RE: Marian Meadows Development Agreement (DV-19-00001) – First Review and Request for Corrections/Additional Information

This letter is to provide you the County's first review comments, a request for corrections and additional information, and a status update on your project, Marian Meadows Development Agreement (DV-19-00001). As you are aware, this proposal was subject to a 30-day public comment period which ended on July 24, 2019 at 5:00 pm. All comments received were transmitted to you via email on July 31, 2019 and have been attached to this letter for your reference.

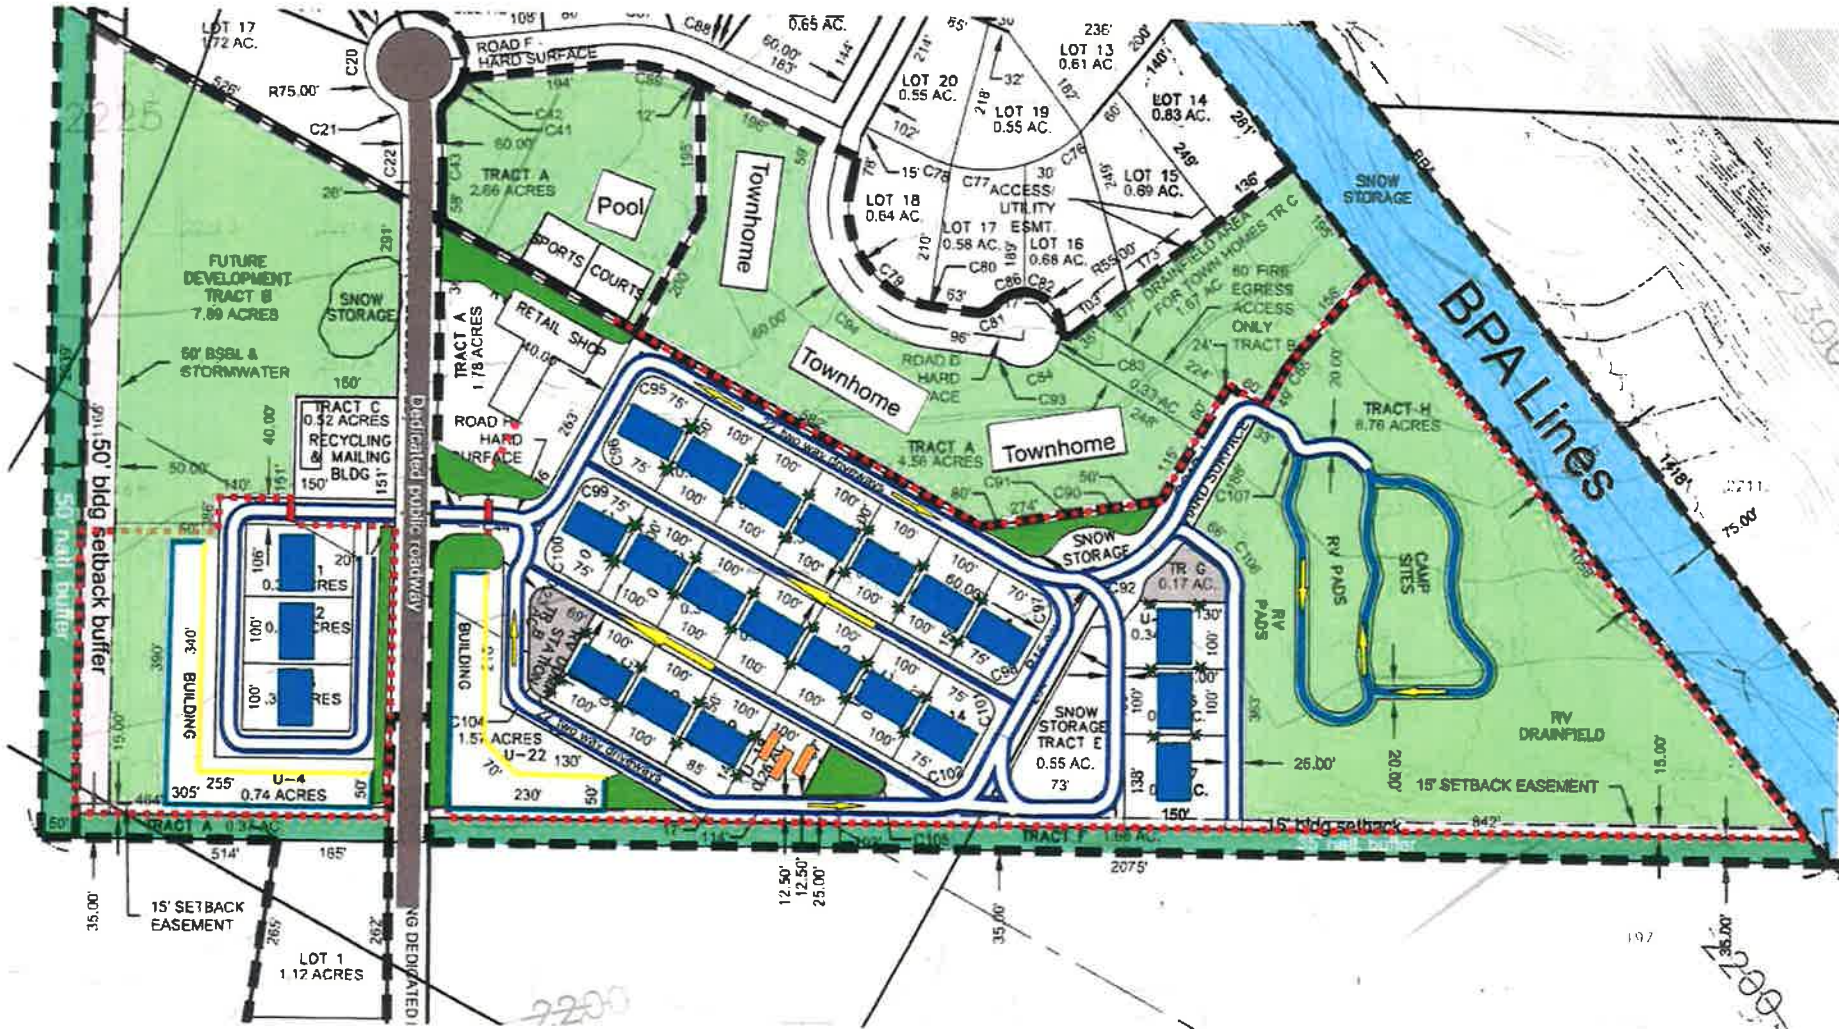
4. The second RV Layout Illustration and RV commercial maps show a fire lane of 14'. Fire lane must be 16'.
 5. Private roads shall comply with the design requirements of 12.04.070 & 12.04.080 Table 4-4 of the Kittitas County 2015 Road Standards.

RV Illustration 1

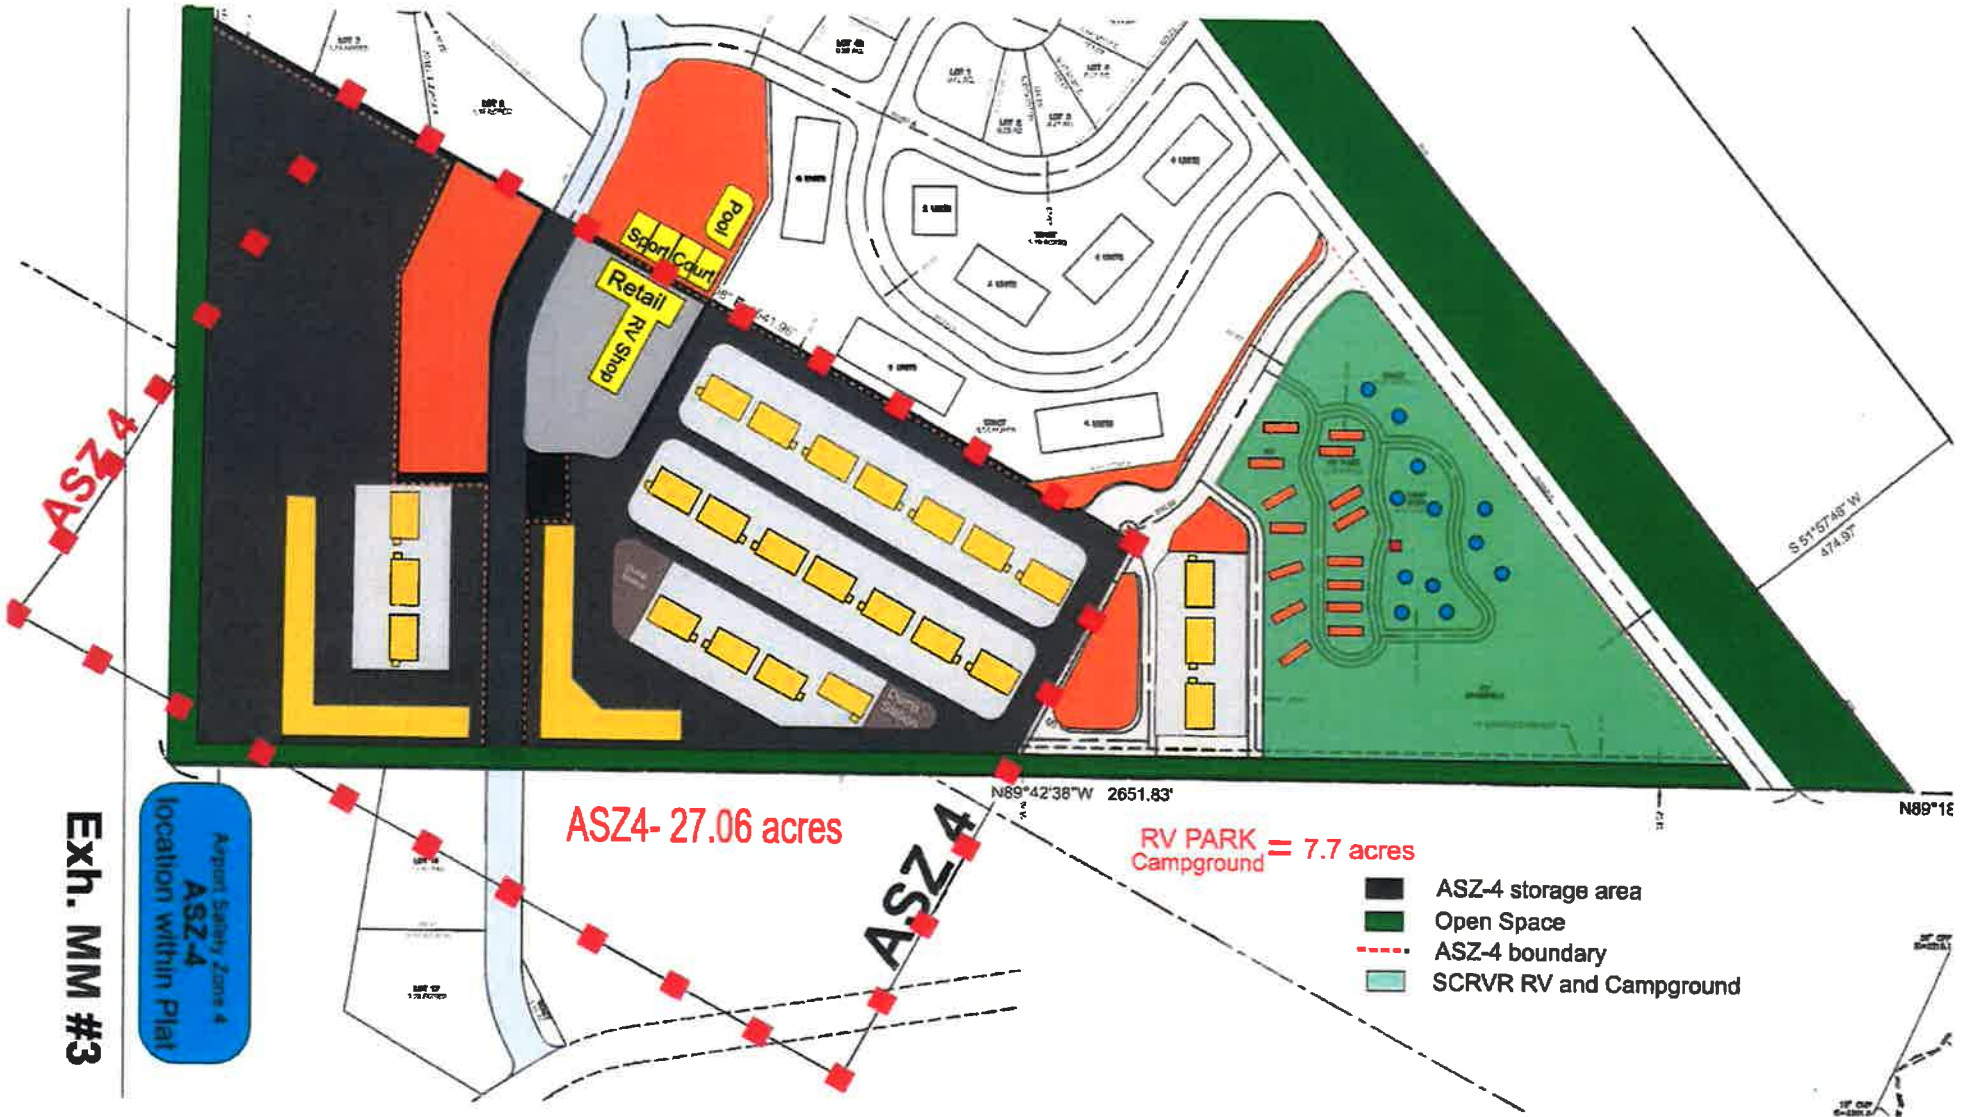
- Engineering:
 1. Specify the quantity of campsites and RV sites.
 2. Identify access to Lot 19 on the RV layout Illustration.
 3. Pursuant to Ordinance No. 2018-006, Public Works' condition of approval 11.3.9 requires a right-of-way (ROW) with sufficient width to allow for the storage of snow within that space without impacting the travel lanes.
